WEST SUSSEX COUNTY COUNCIL CONSULTATION

TO:	Arun District Council FAO: Mrs A Gardener
FROM:	WSCC - PROW
DATE:	5 June 2019
LOCATION:	Land between Ashurst and Badgers Ham Manor Way Littlehampton BN16 4JQ
SUBJECT:	A/55/19/PL Construction of 1 No. new two storey house (resubmission following A/31/19/PL). This application is a Departure from the Development Plan & affects a Public Right of Way.
DATE OF SITE VISIT:	n/a
RECOMMENDATION:	No Objection
S106 CONTRIBUTION TOTAL:	£ See below for breakdown.

Site Plan (1:200)

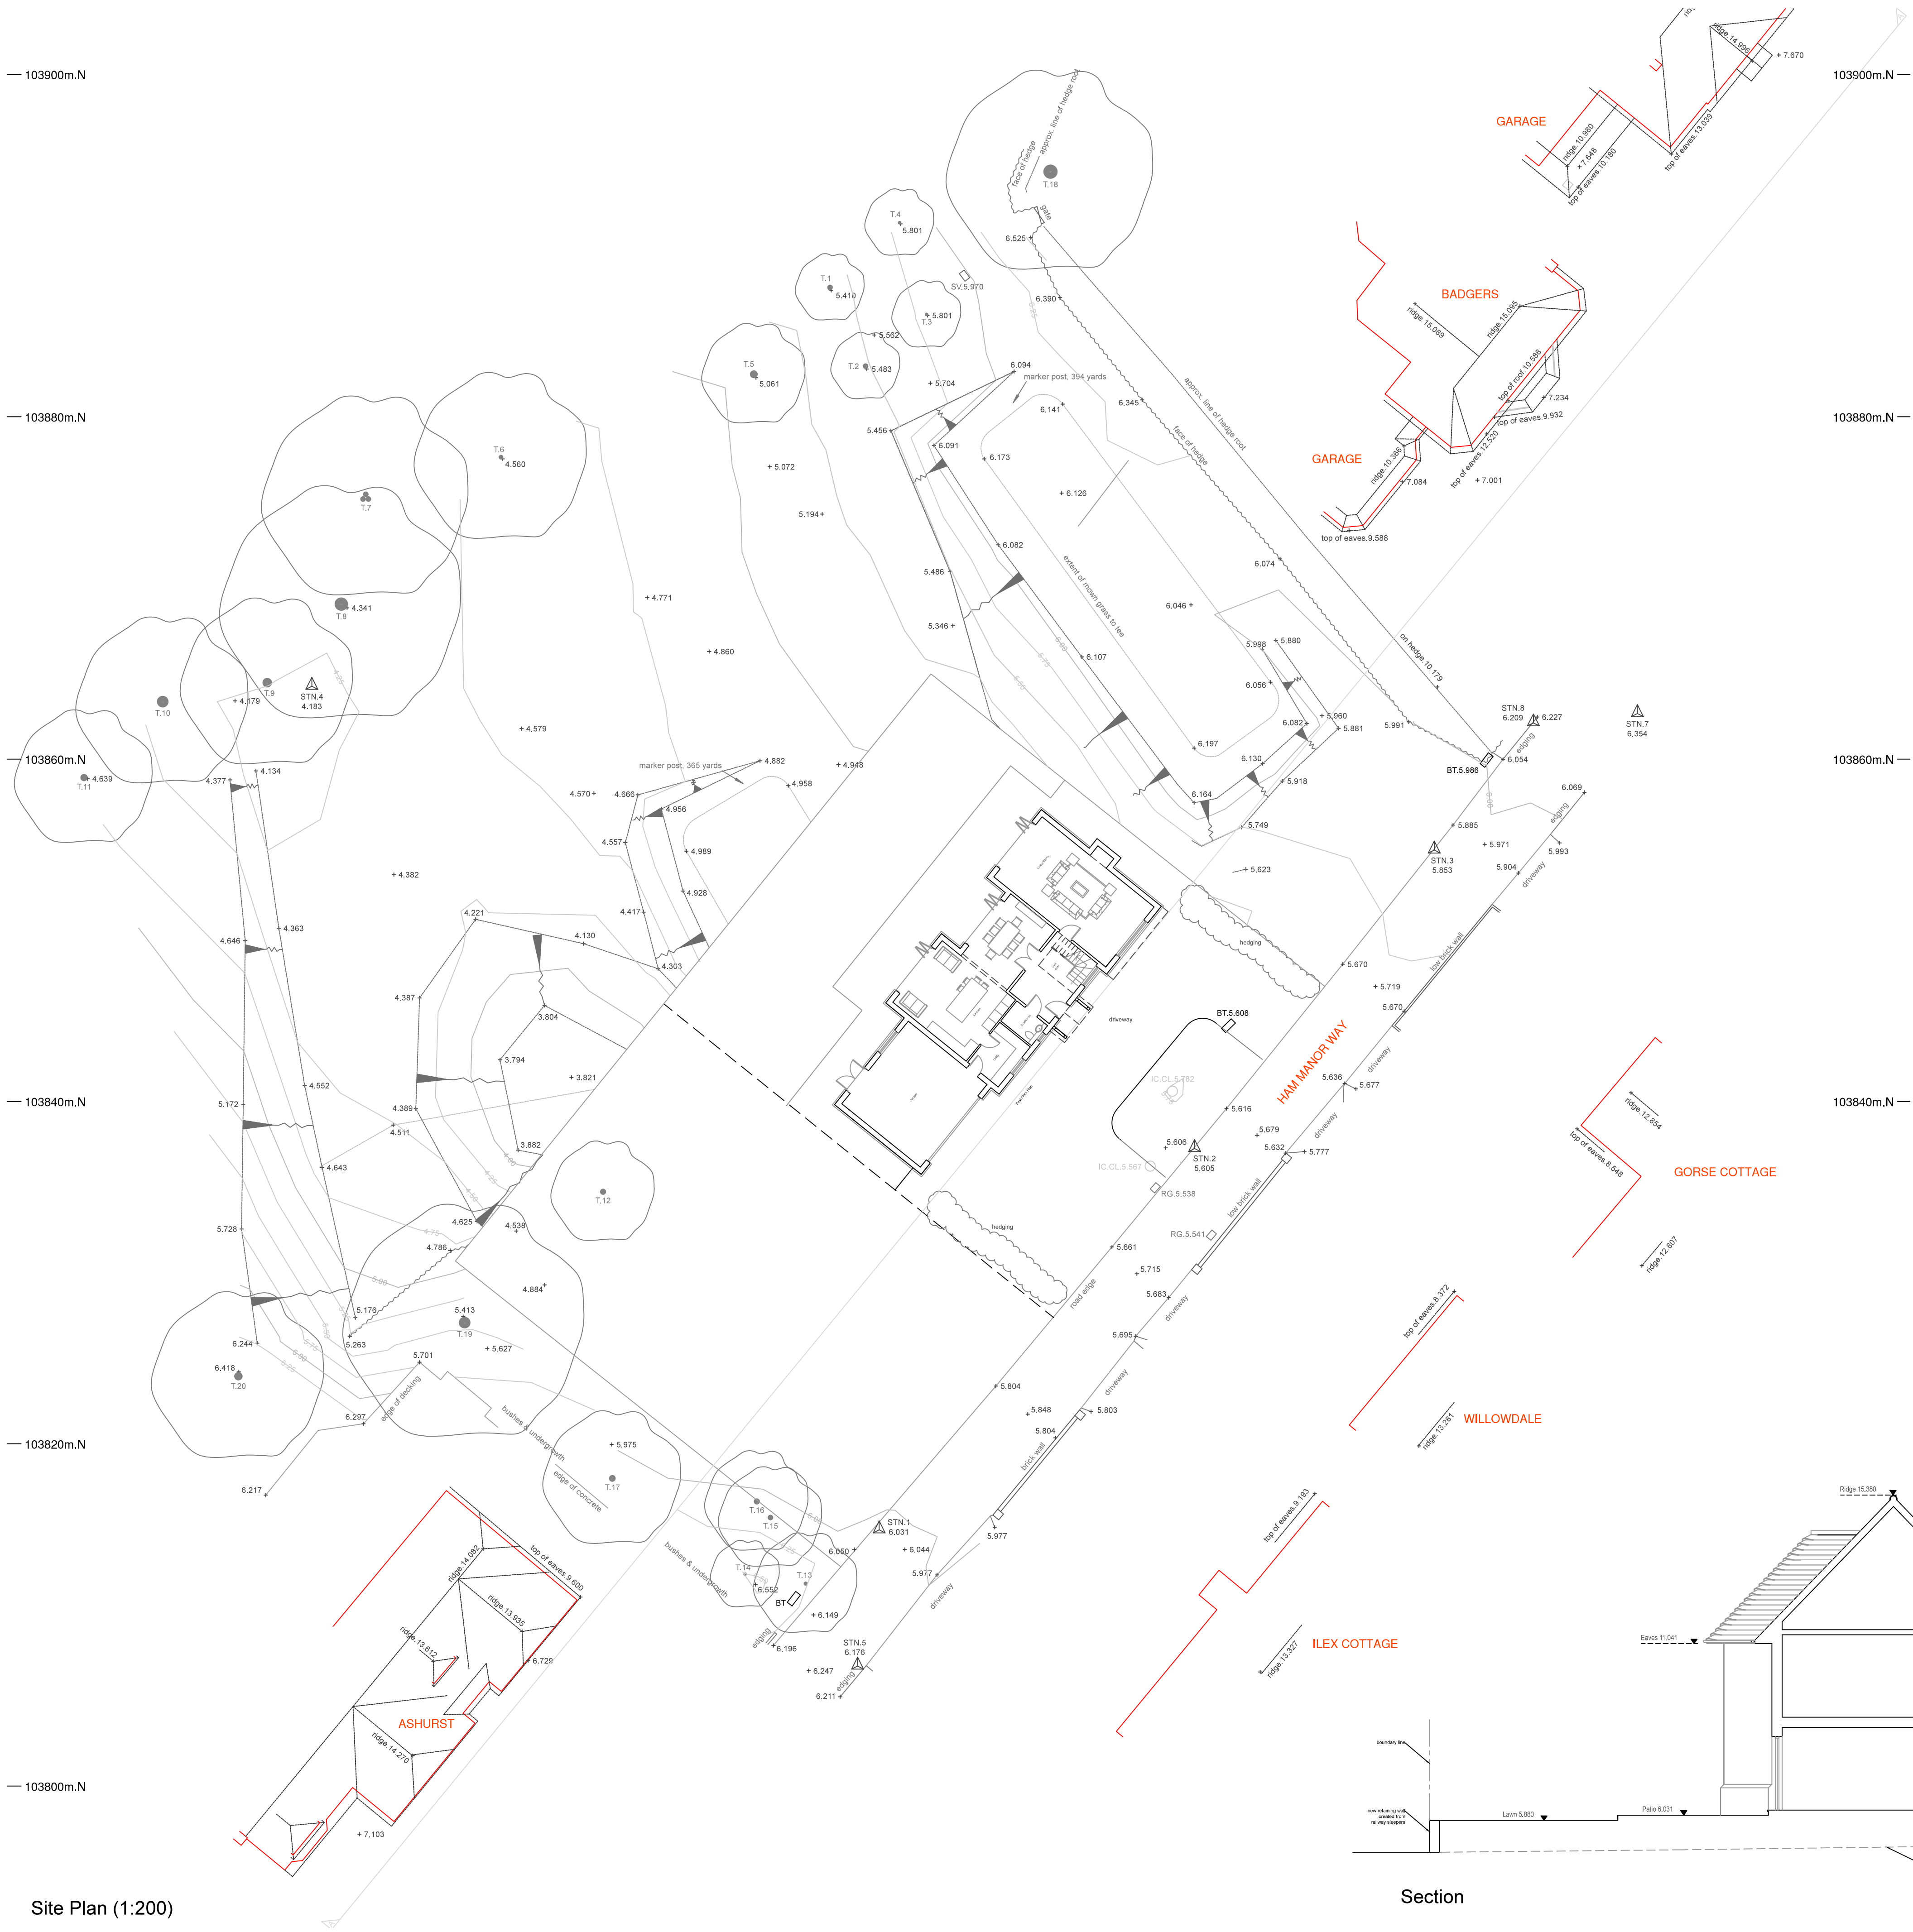
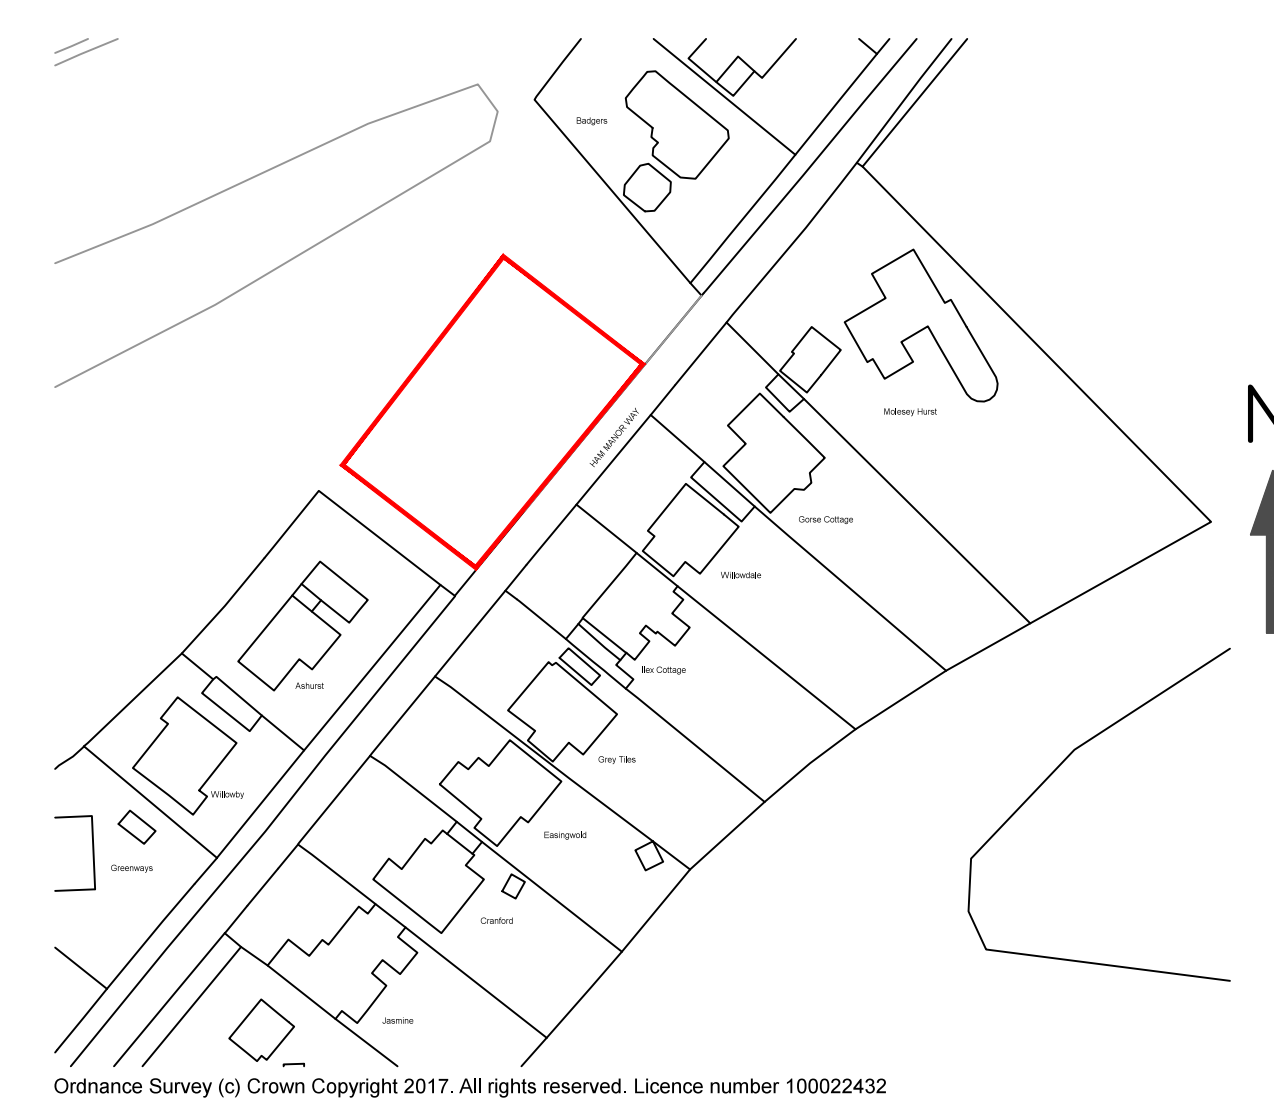
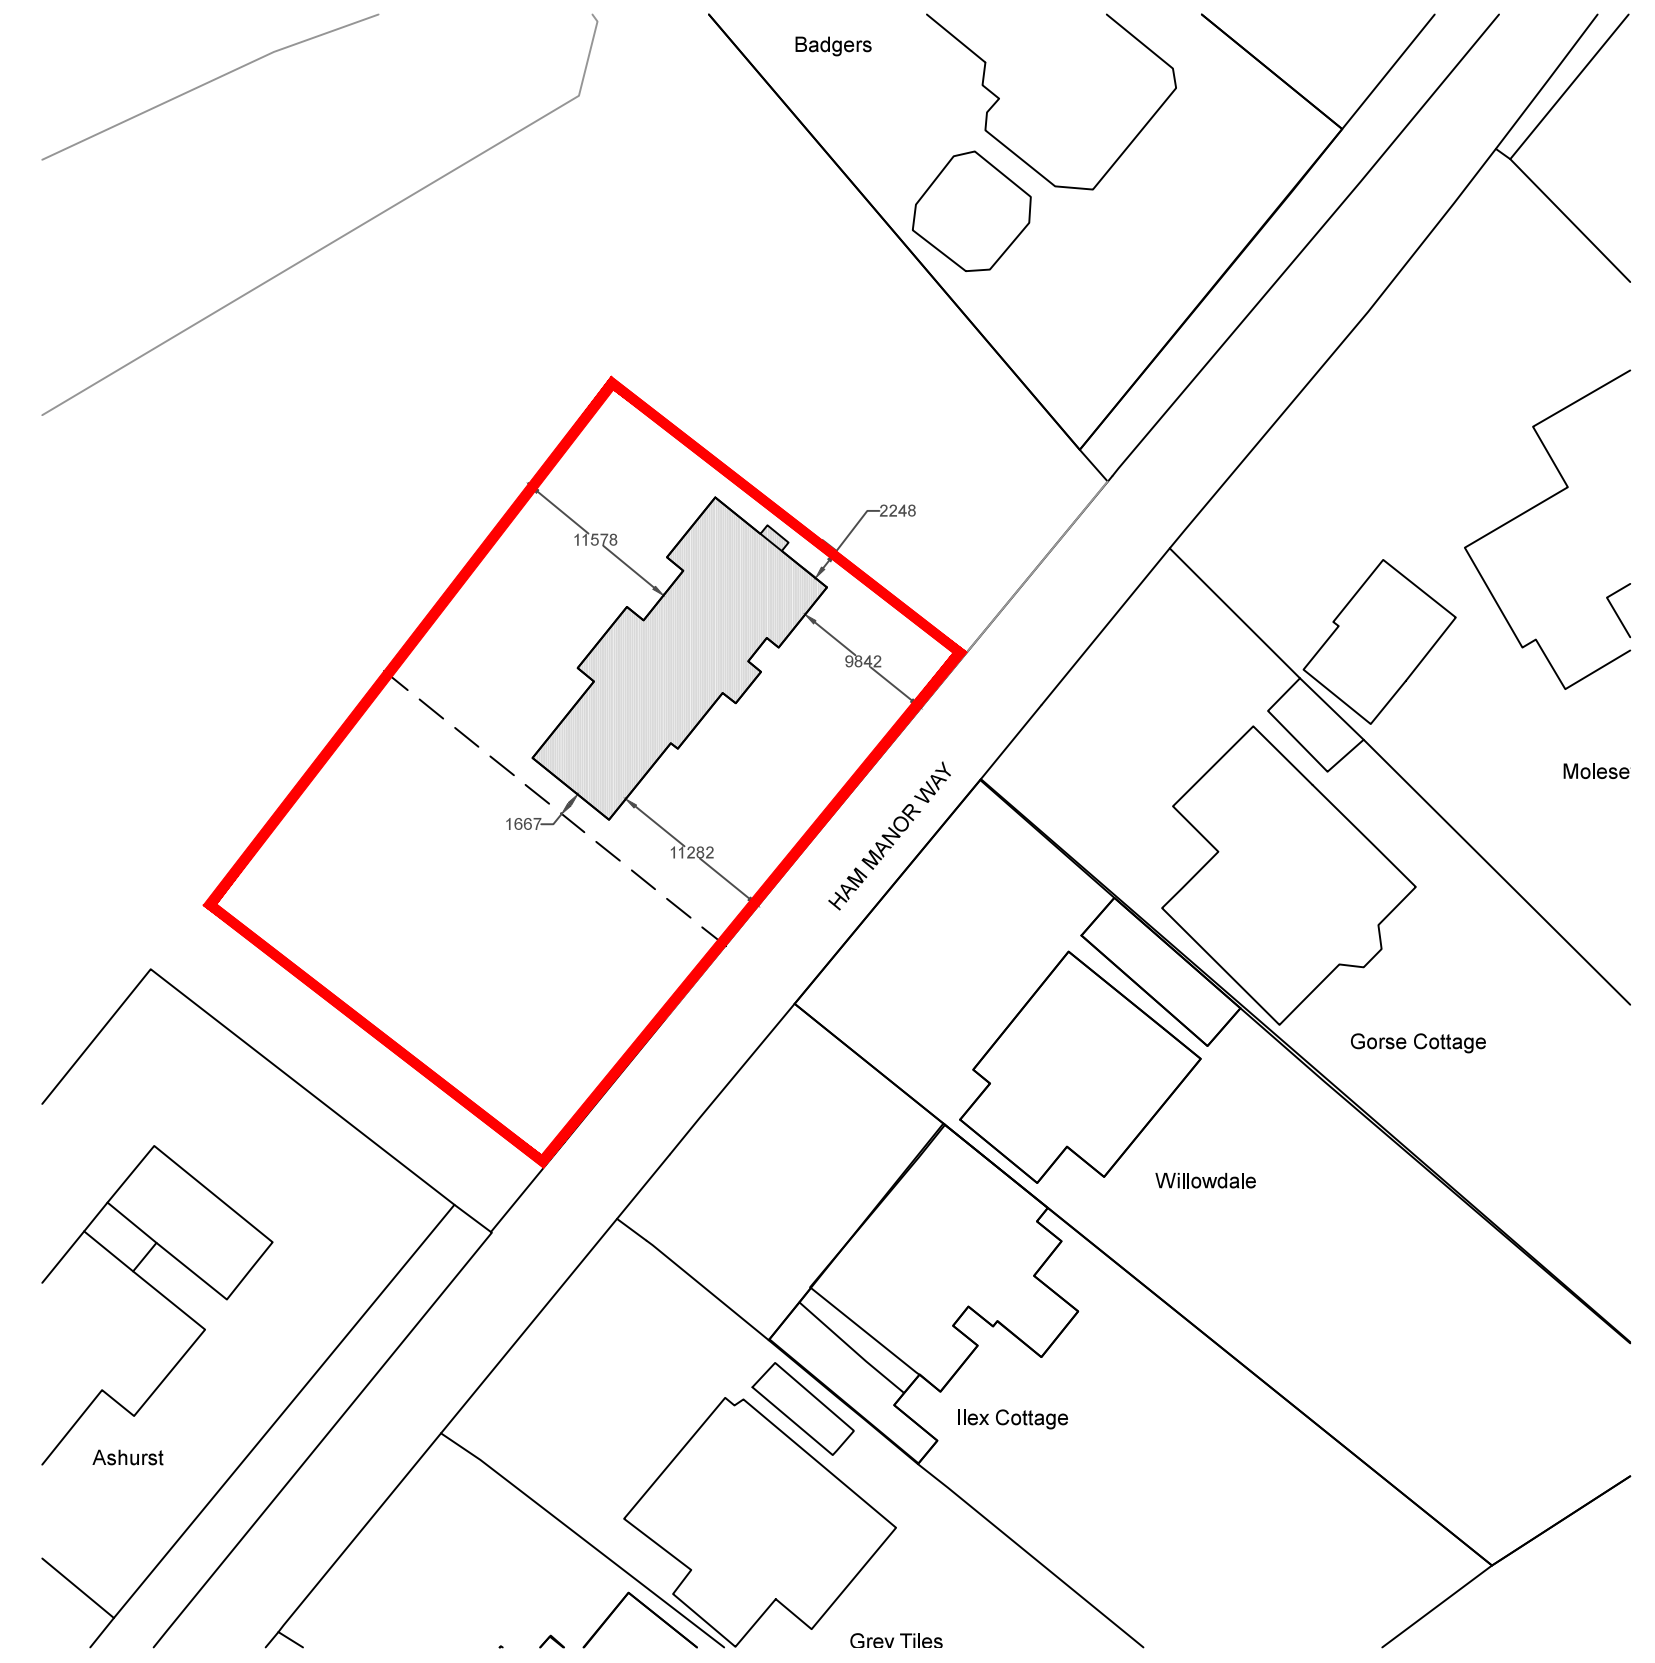
The PROW affected by this proposal is FP2195 as it runs adjacent to the development site's eastern boundary, along the private road known as Ham Manor Way.

Ham Manor Way, FP2195, is used for vehicular access to existing houses and for the proposed development. As the applicant's site plan does not show any adverse effect to the footpath and there are no plans to realign the route we would have no objection to this application as long as the following comments and guidance are followed:

At no stage can this footpath (the entire width of the road) be restricted or obstructed and any vehicles using this route should give way to lawful path users as the pedestrian right of access takes precedent over any private rights of vehicular access.

While the development is underway, safe & convenient public access is to be available at all times across the full width FP2195 and the route cannot be obstructed by vehicles, plant, scaffolding or the temporary storage of materials and/or chemicals during any works.

Any alteration to, or replacement of, the existing boundary with the PROW or the erection of new fence lines, must be done in consultation with WSCC's PROW Team to ensure the legal width of the footpath is maintained and there is no unlawful encroachment. Should planning consent be approved by the Local Planning Authority this would not confer consent for such fencing of the PROW, which would require a separate application to WSCC's RoW Team.

Any down pipes or soakaways associated with the development should discharge into an existing or new drainage system and away from the surface of the PROW. No drainage system is to be installed through the surface of the path without the prior consent of WSCC's PROW team.
